AB/46/22/L

2 Maltravers Street Arundel BN18 9AP

Listed building consent for the change of use of building from residential (C3) to a mixed use of residential and art gallery (Class E).

PLANNING
PROPOSED SIGNAGE AND LIGHTING
DATE: APRIL 2022
SCALE: 1:5 @ A3
JOB No. 1131
DRWG No. 122
Rev /

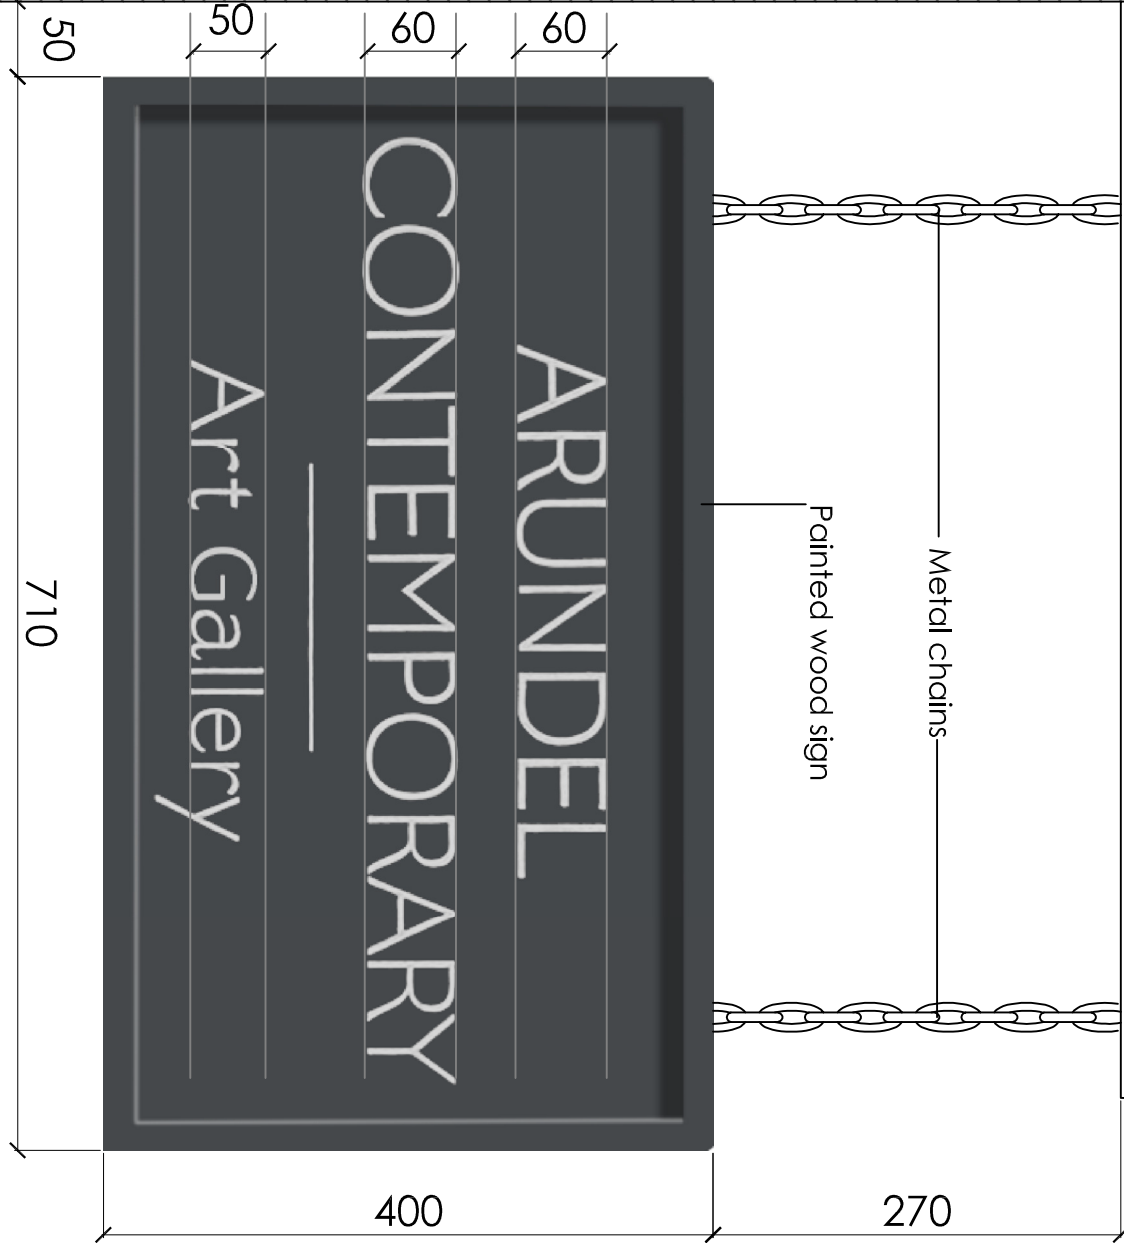
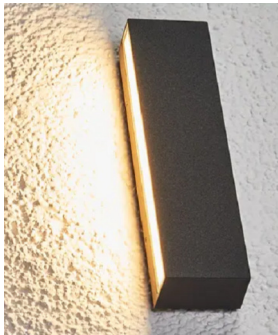
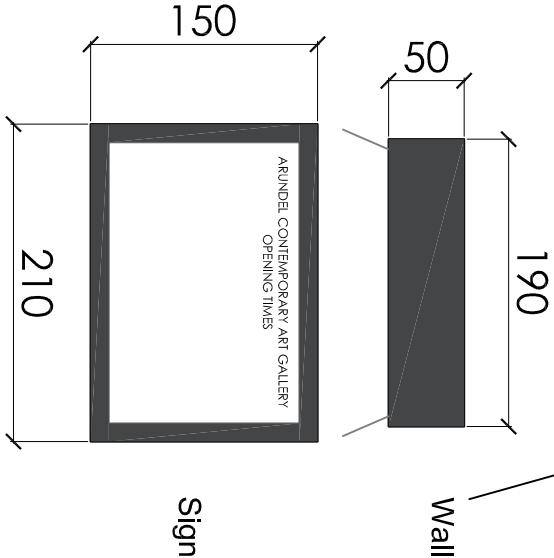
The town centre contains number of uses including residential, restaurant and retail. As a result, the introduction of a mixed-use property to this location would not be out of character or cause harm. Likewise, the information panel and light, along with the new hanging sign are considered to be acceptable. When installing the signage and lighting the applicant should stick to the principles of reversibility so that no part of the installation leaves a permanent scar. This means using methods like only fixing into mortar joints and not the brick.

PROPOSED ELEVATIONS AND SIDE VIEW

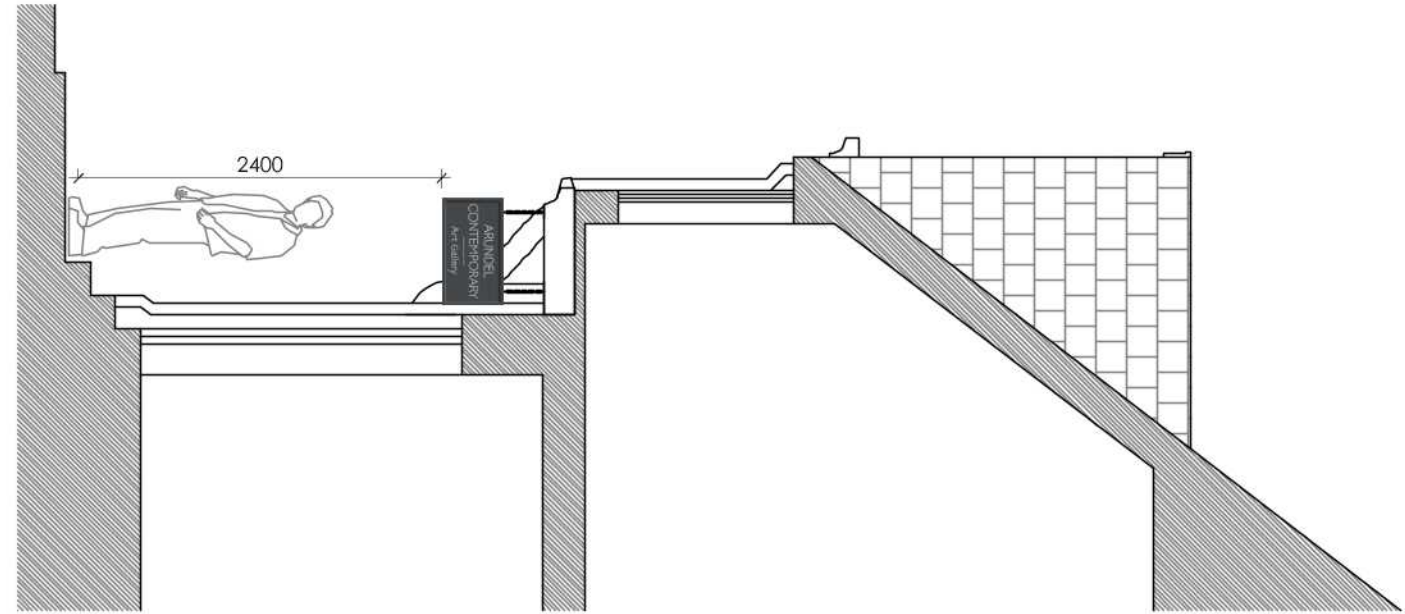
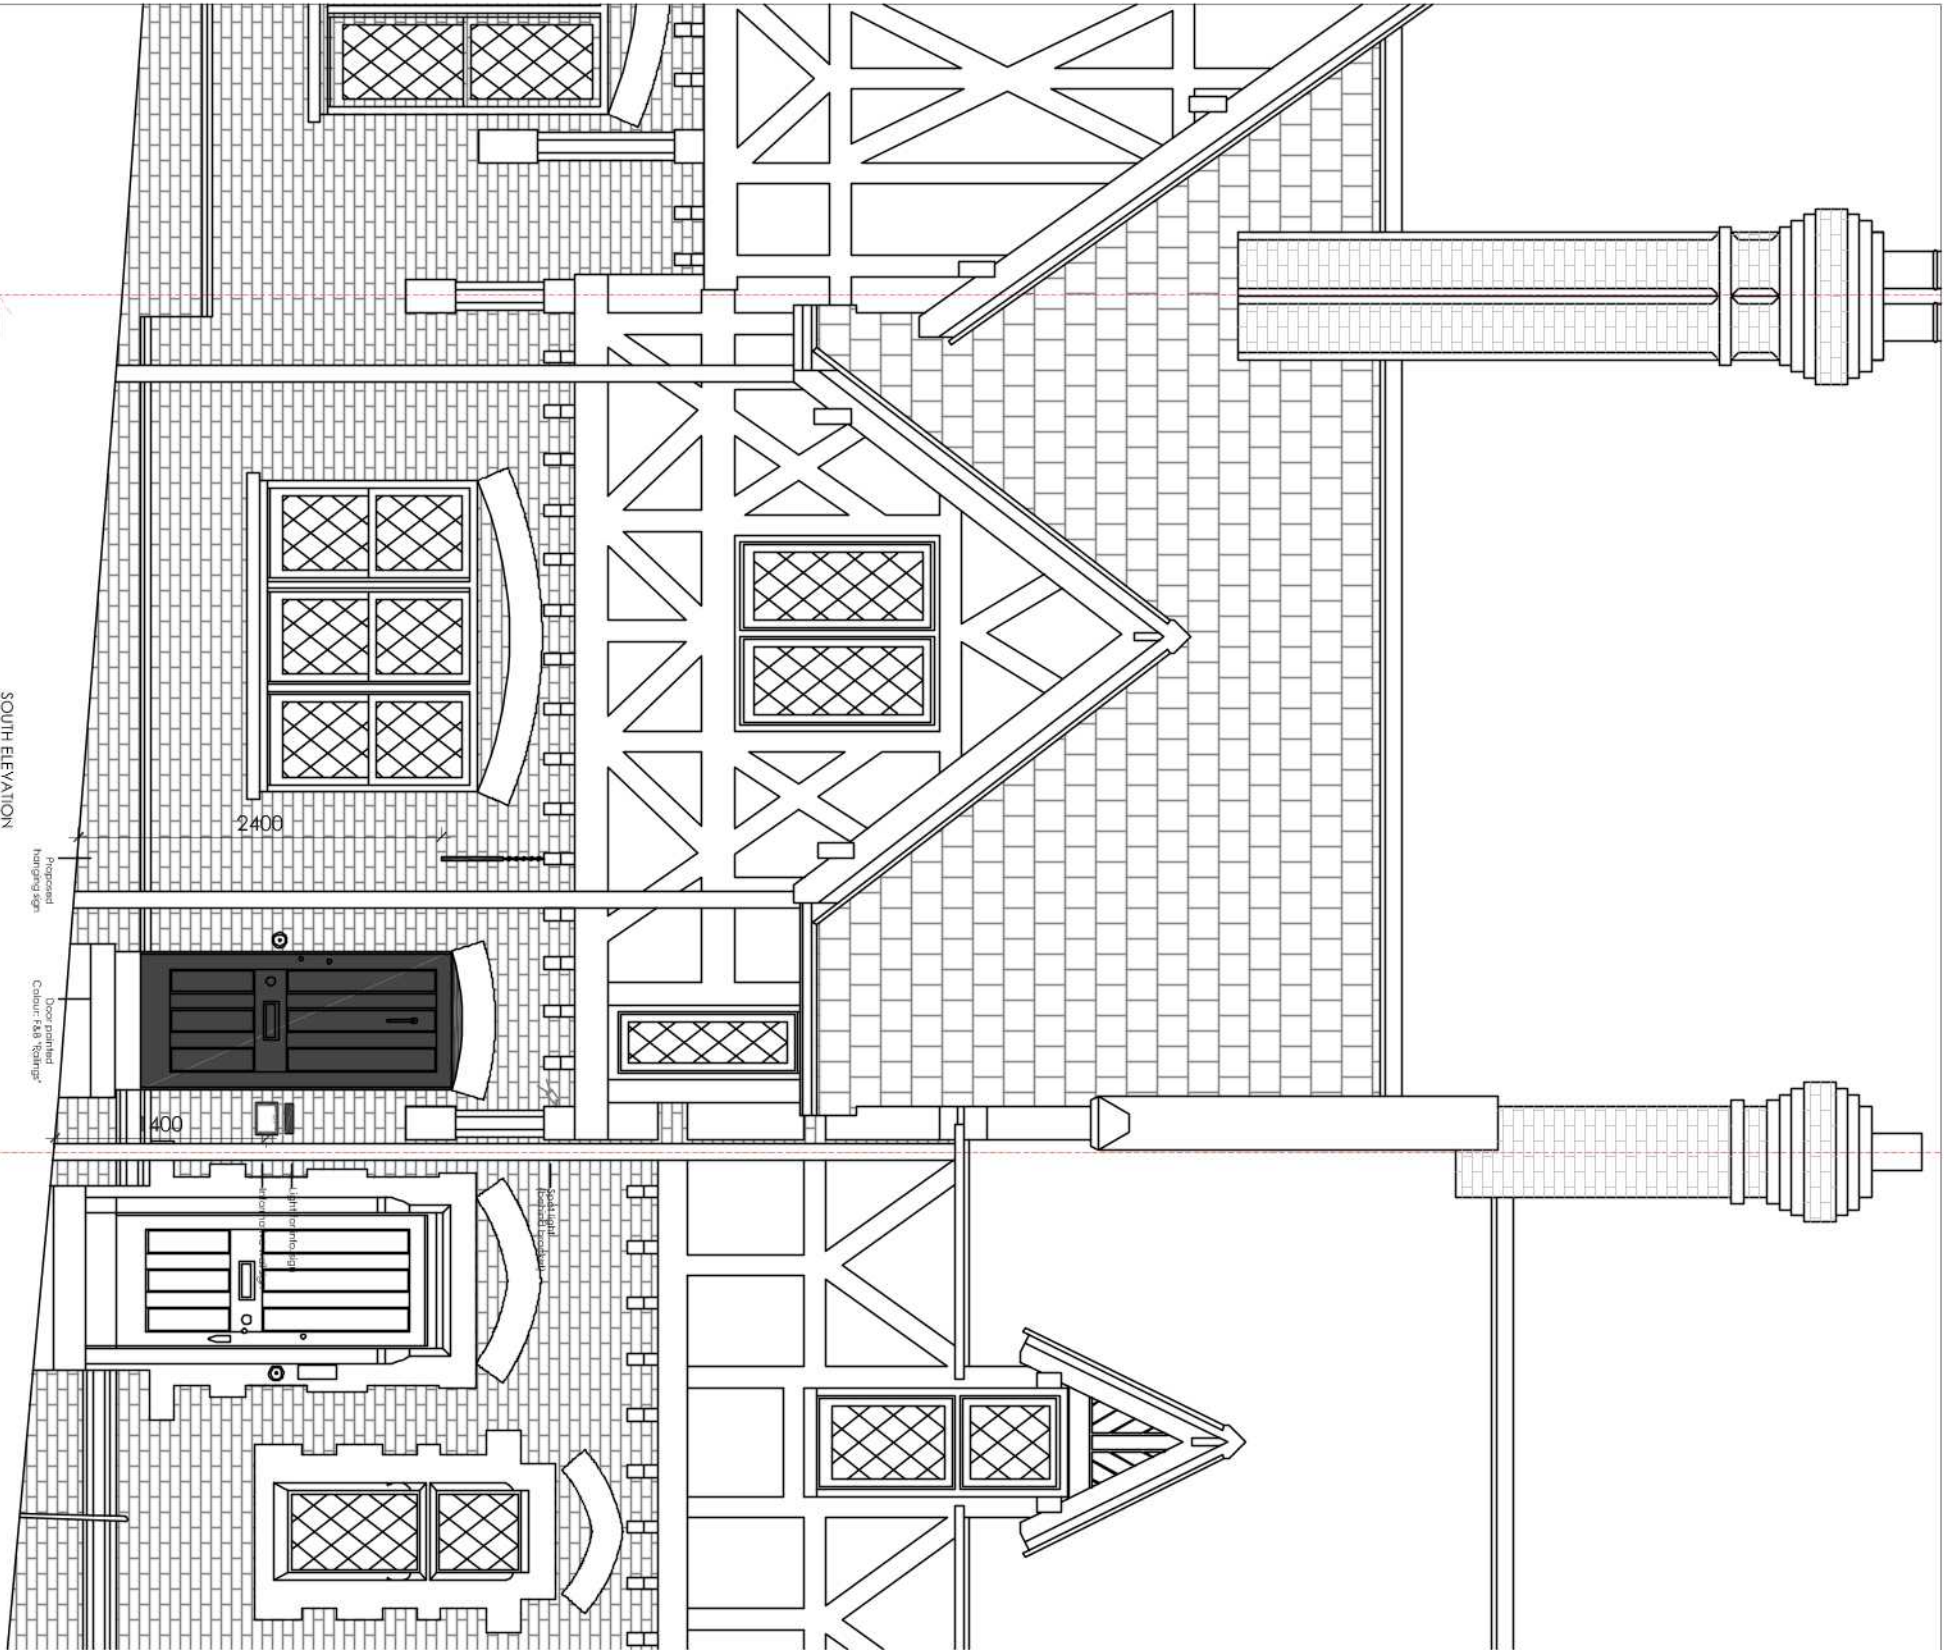
However, the painting of the oak front door is problematical. The existing door looks like the other two front doors on the Maltravers Street frontage which are of unpainted oak, and which appears entirely appropriate to the late C.19 Tudoresque style. This is supported by the fact that they are identified within the listing description. Changing the finish of the door would be out of character with the original design for the elevation and would conflict with the other oak doors. Such an impact would be harmful and not capable of support.
